Zoning Committee

Current Zoning: NS (neighborhood services)
Proposed Zoning: I-2(CD) (general industrial, conditional)

Approximately 9.84 acres located on the south side of Old Dowd Road at the intersection with Sam Wilson Road.

Turnstone Group, LLC

**CONCEPT PLAN - L-2**

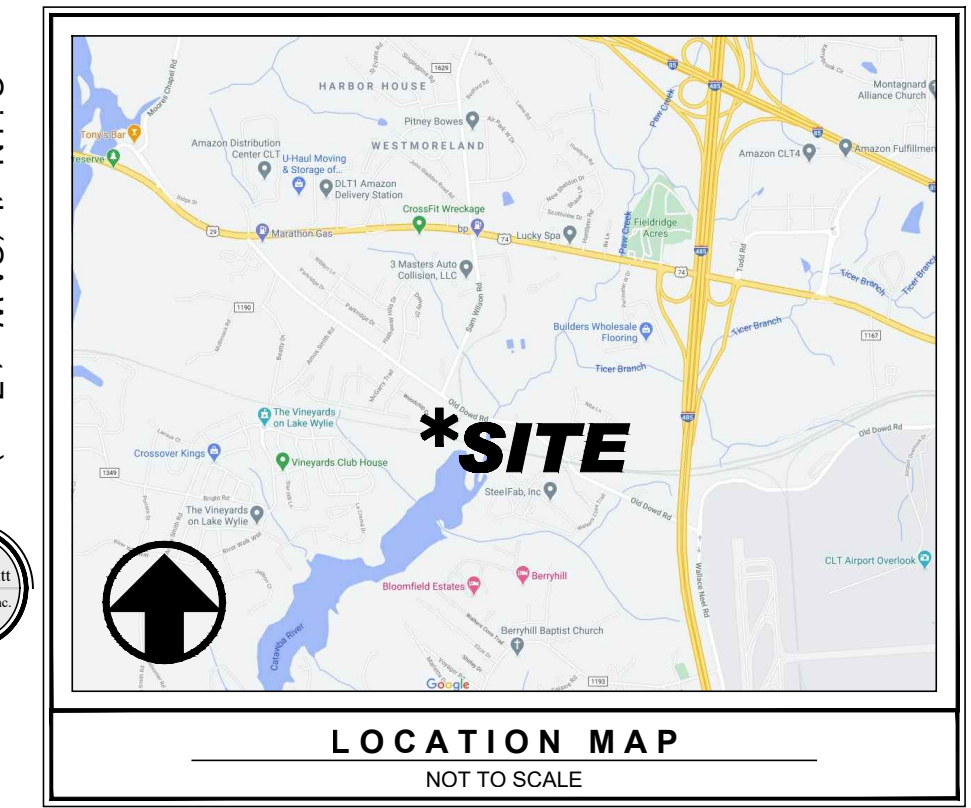
Commissioner Lansdell asked for clarification regarding the buffer and berm. Staff replied that the ordinance requires a 73' buffer but allows a provision to reduce the buffer by 25% if a berm is included. The petitioner is exercising the buffer reduction option by adding a berm and reducing the buffer to 54.5'.

Chairperson Welton asked if the entrance driveway is sized to accommodate the boats and large vehicles that are expected to access the site. CDOT staff replied that the driveway type is usually not addressed at the rezoning stage but would be during permitting and staff would ensure that it would accommodate large vehicles.
